Subject: P/140/16/OUT - amendments to the original application relating to the submission of additional drawing and revised cumulative transport assessment & response to developer comments

Nicola Jones
Clerk & RFO
Pagham Parish Council

Figure 13.4 – Proposed mitigation at the B2166 junction with Vinnetrow Road

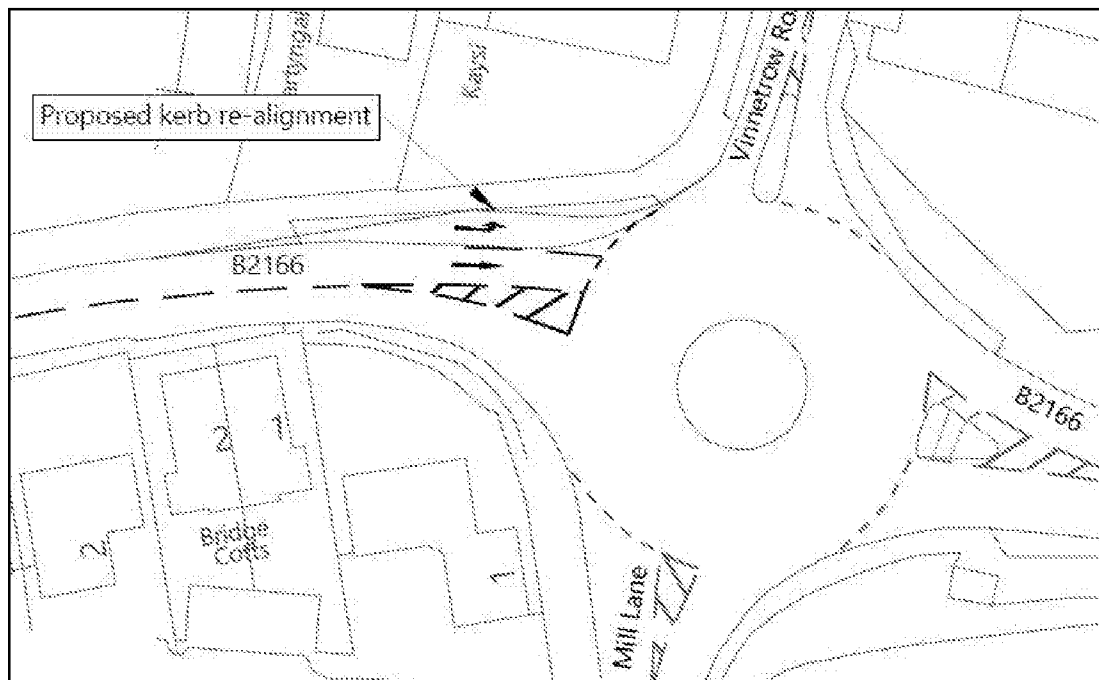
The small amount of widening at approaches to Hunston and Vinnetrow roundabouts can only be regarded as “peripheral tinkering” as we contend that there has been no real effort to deal with, or cost, the very real problems which require detailed consideration if the local road network was to be expected to cope with the projected new traffic levels that would be consequential upon proposed development
